DRB CASE NO/PROJECT NO: 1002404

SUBJECT: Project # 1002404

On November 15, 2007, the Environmental Planning Commission approved Project # 1002404/07EPC-40050 and 40051, a request for a site development plan for subdivision and a site development plan for building permit for Lots 1B and 1D, Ladera Industrial Center, located Unser and Vista Oriente NW.

Lots 1-B & 1-D, Ladera Industrial Center

1 MONUMENT SIGN  
UNSER BOULEVARD &  
VISTA ORIENTE STREET  
TOTAL SIGN AREA: 74.94 SF.

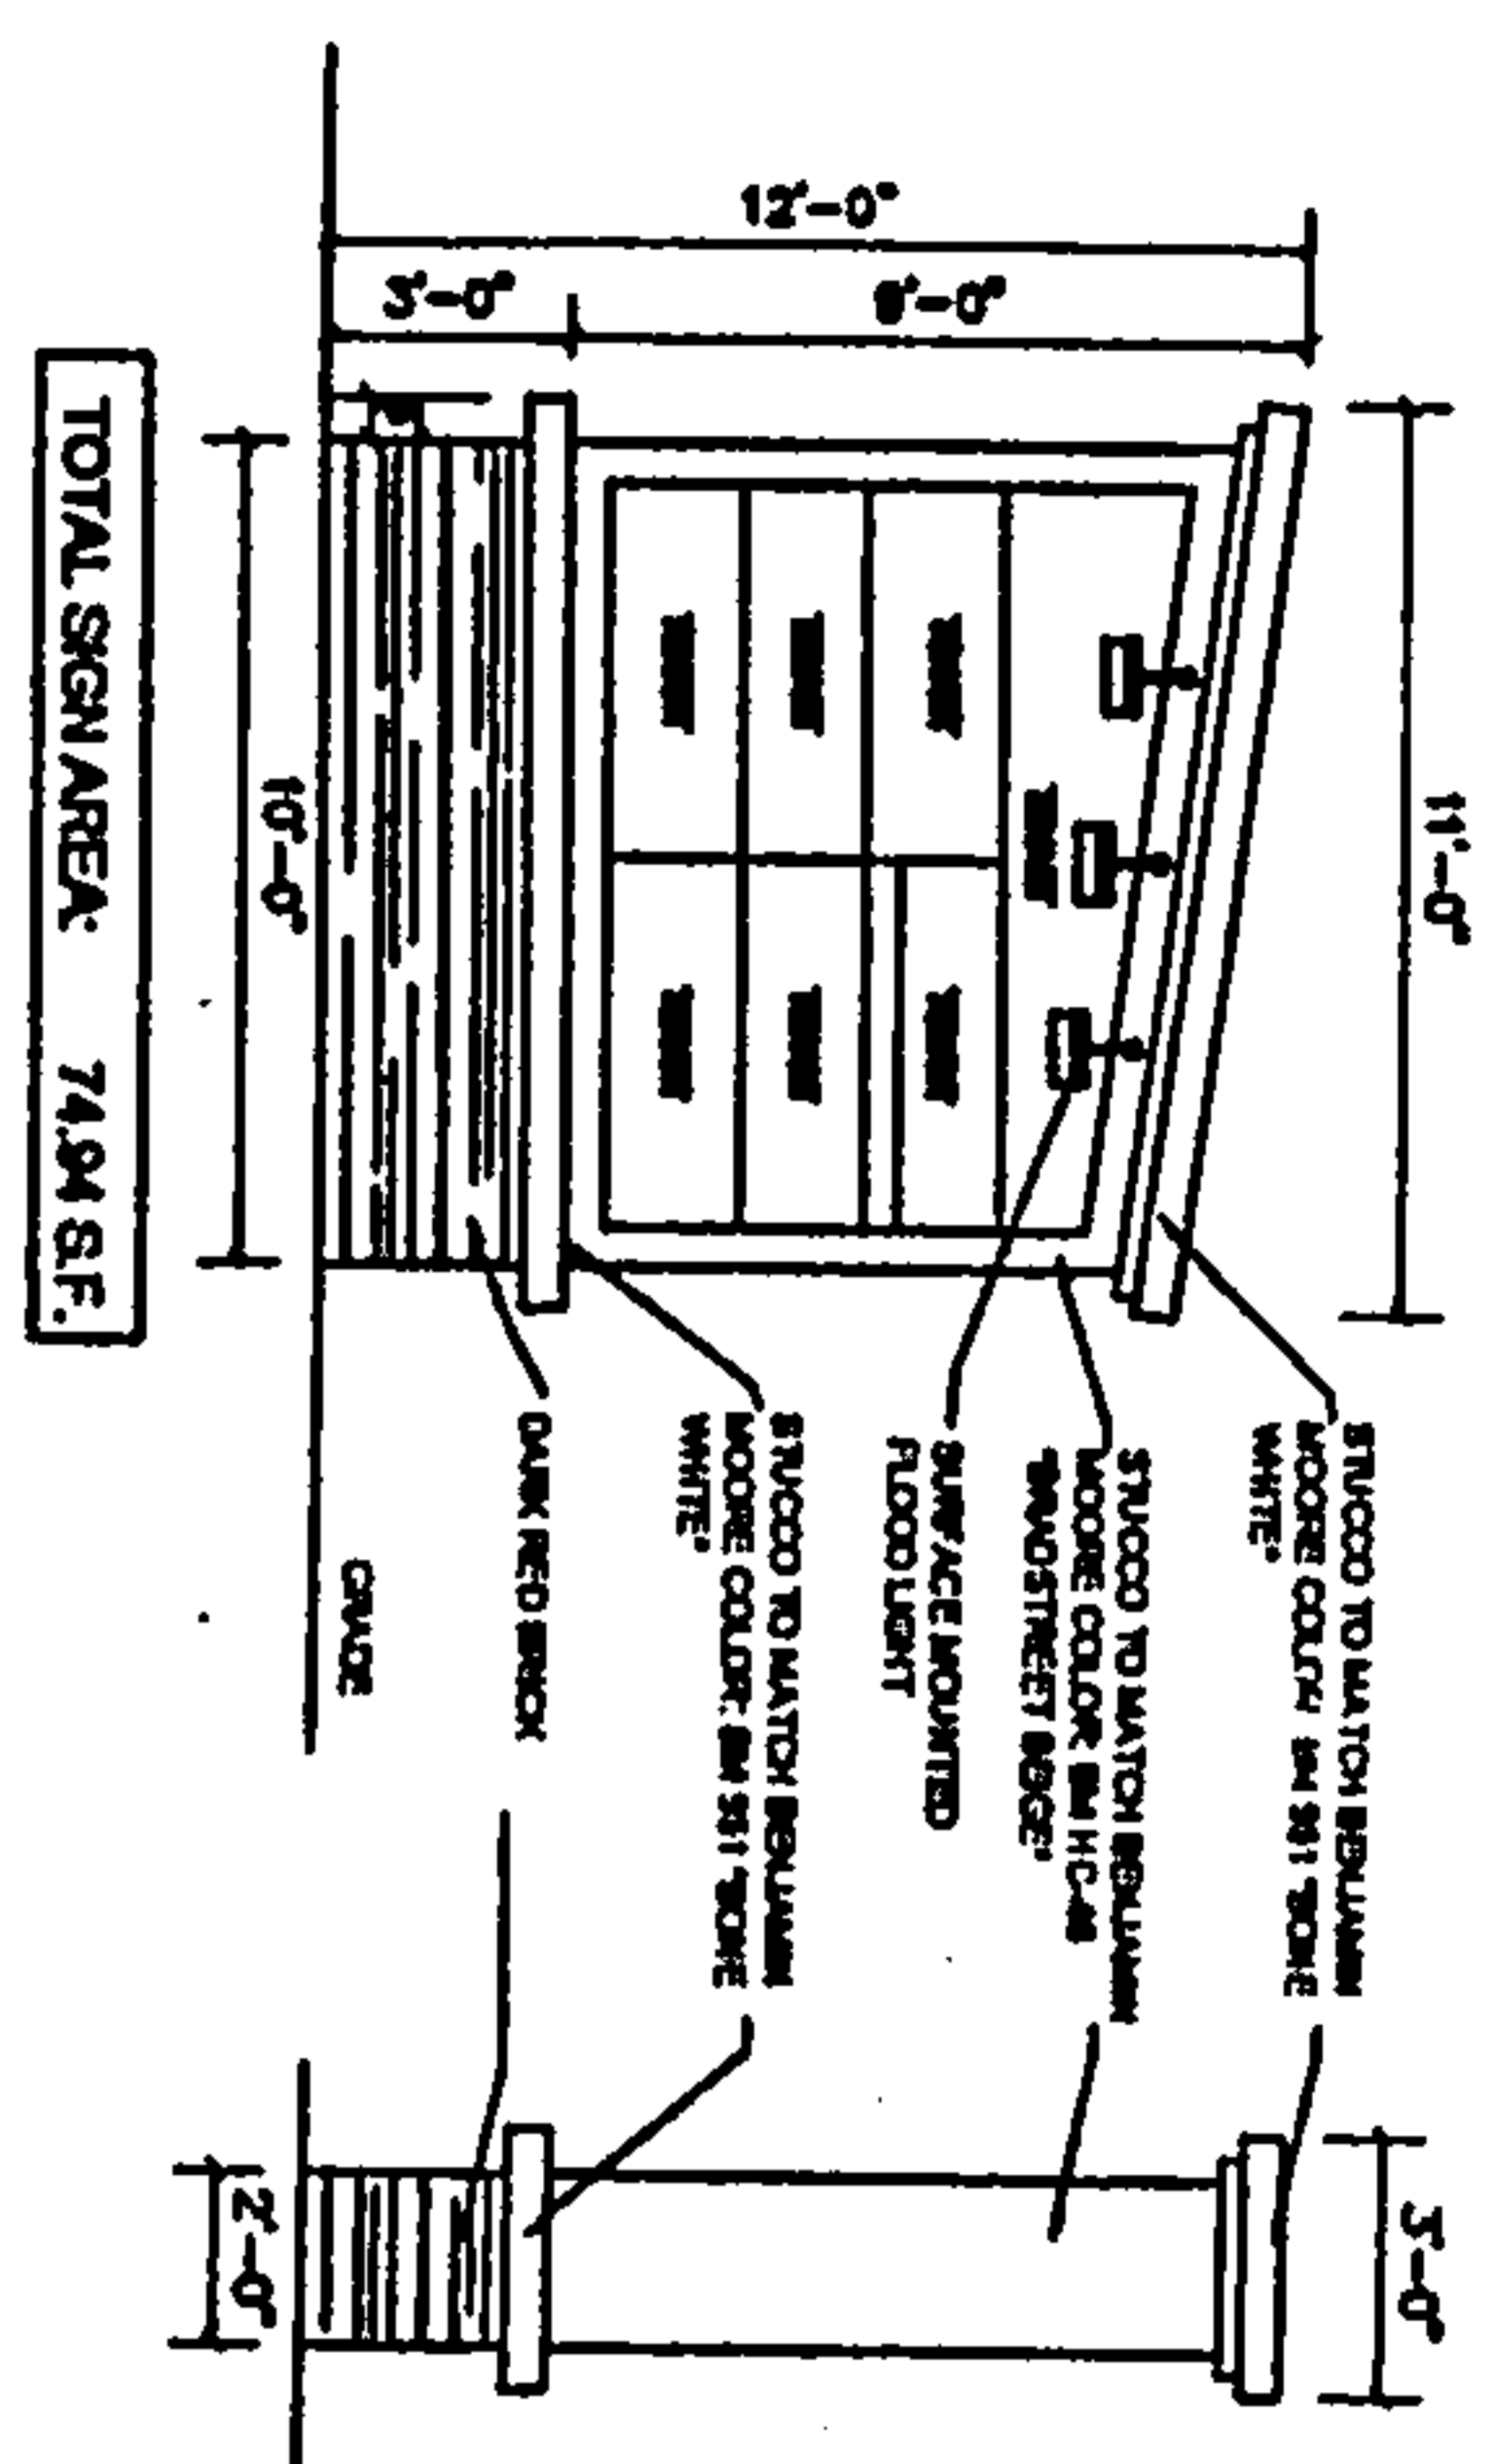
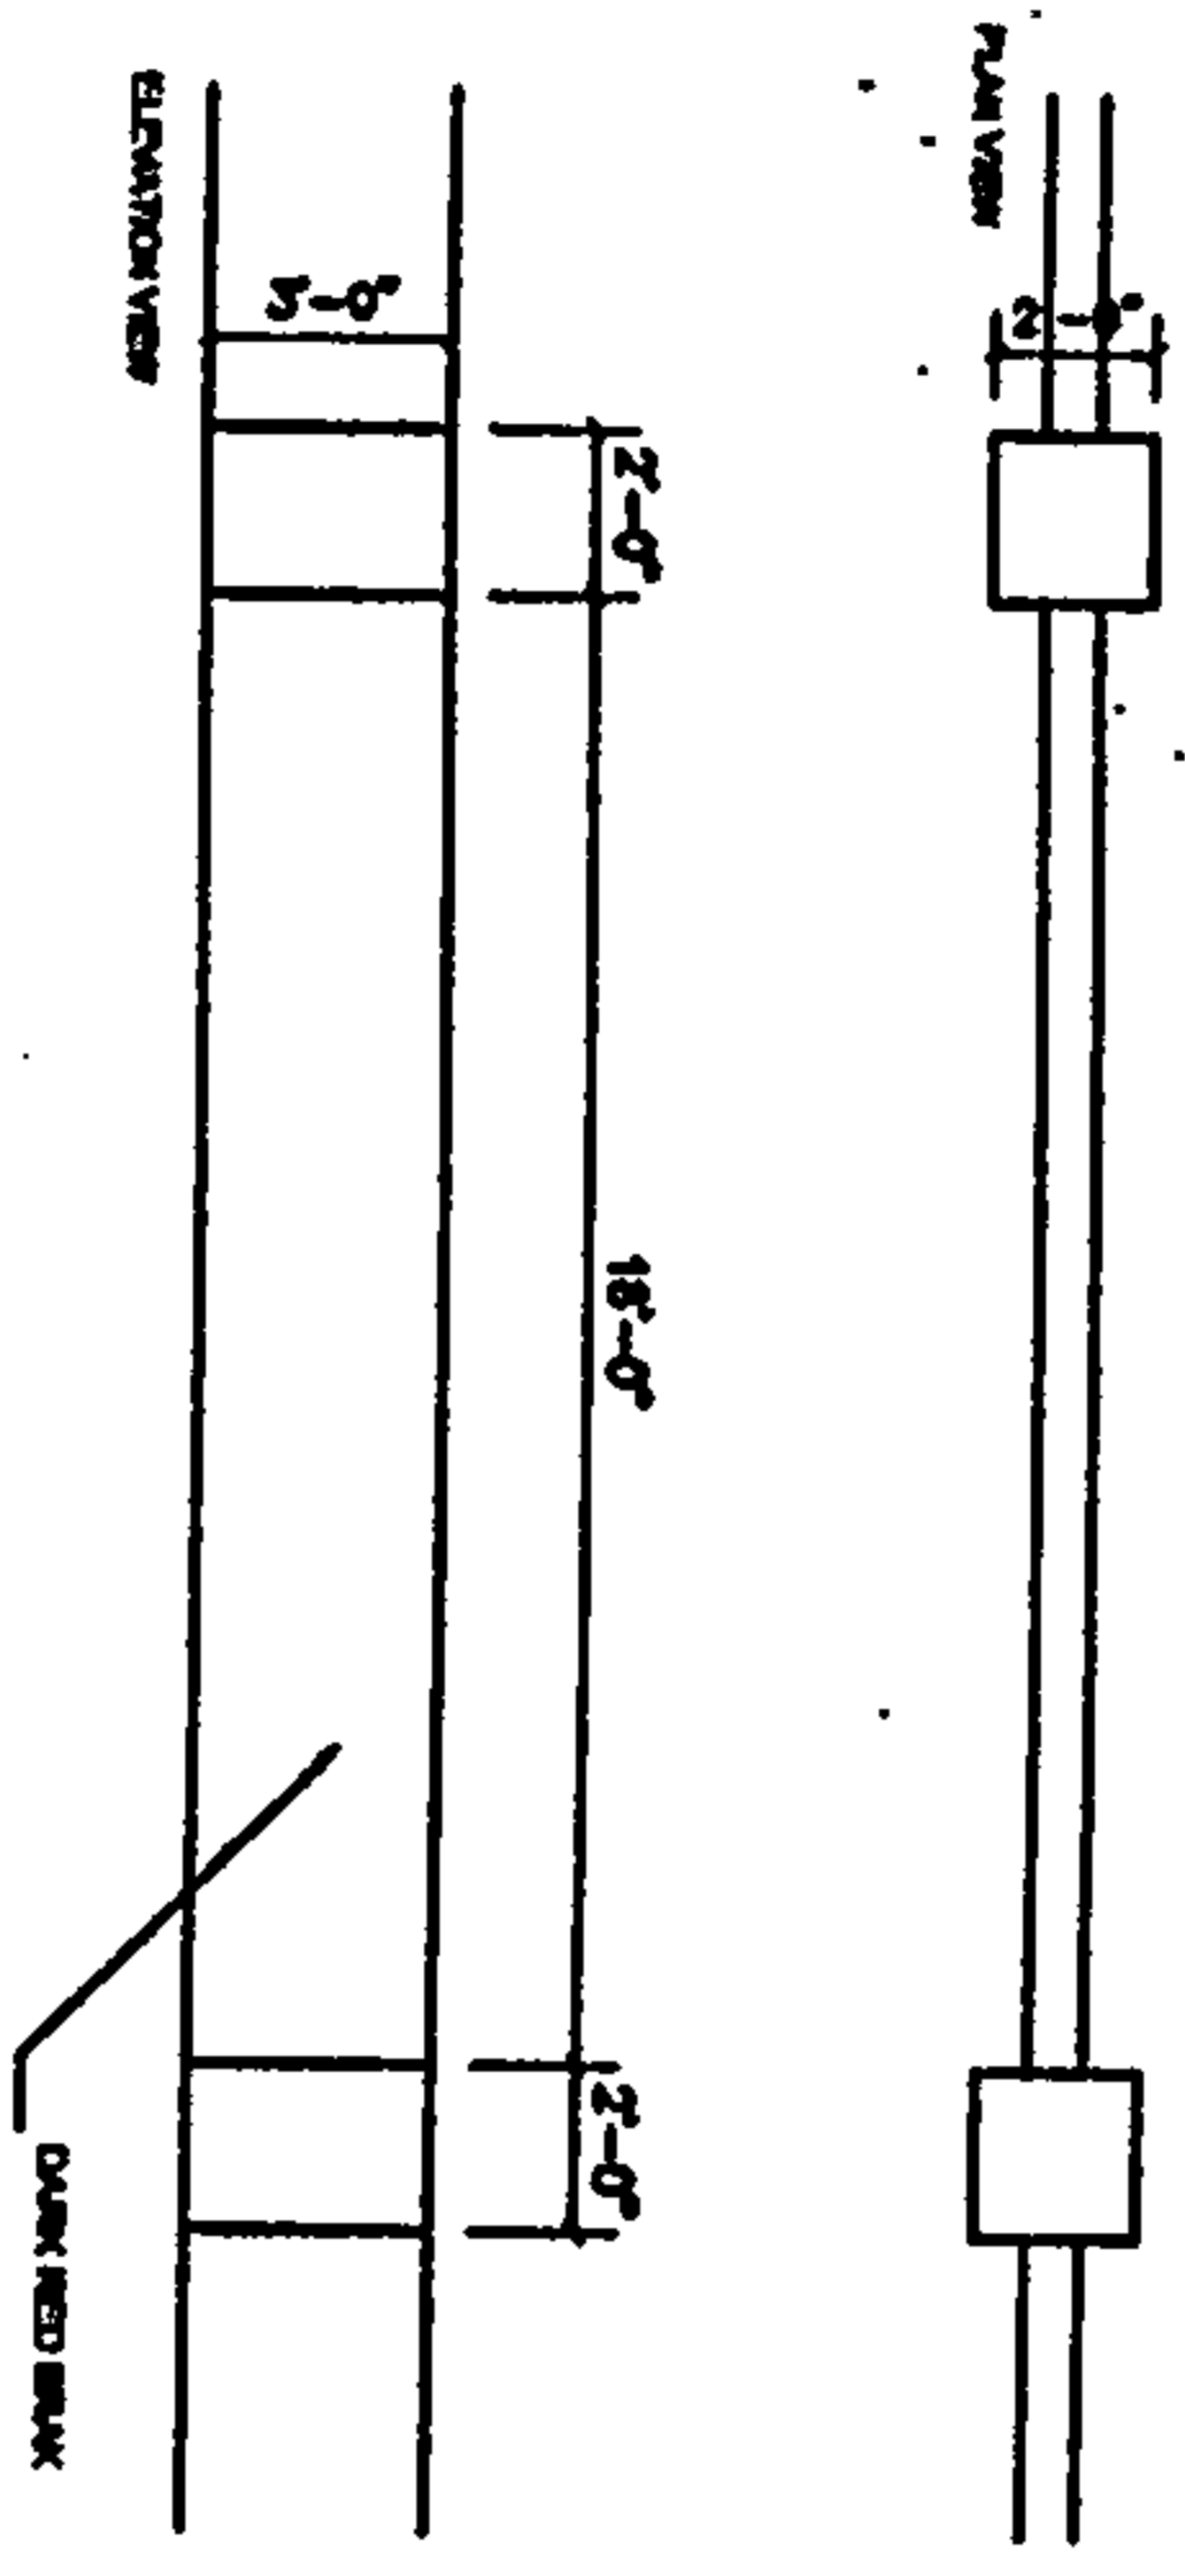
1. Condition #3c requires the applicant to specifically state that 75% live groundcover shall be provided for **each** landscaping area.
2. Condition #3e allows the applicant two 12-foot signs along Vista Oriente. As written, the design guidelines would only permit one such sign. The applicant should be made aware that the current language of the design guidelines is more restrictive than what the EPC approved.
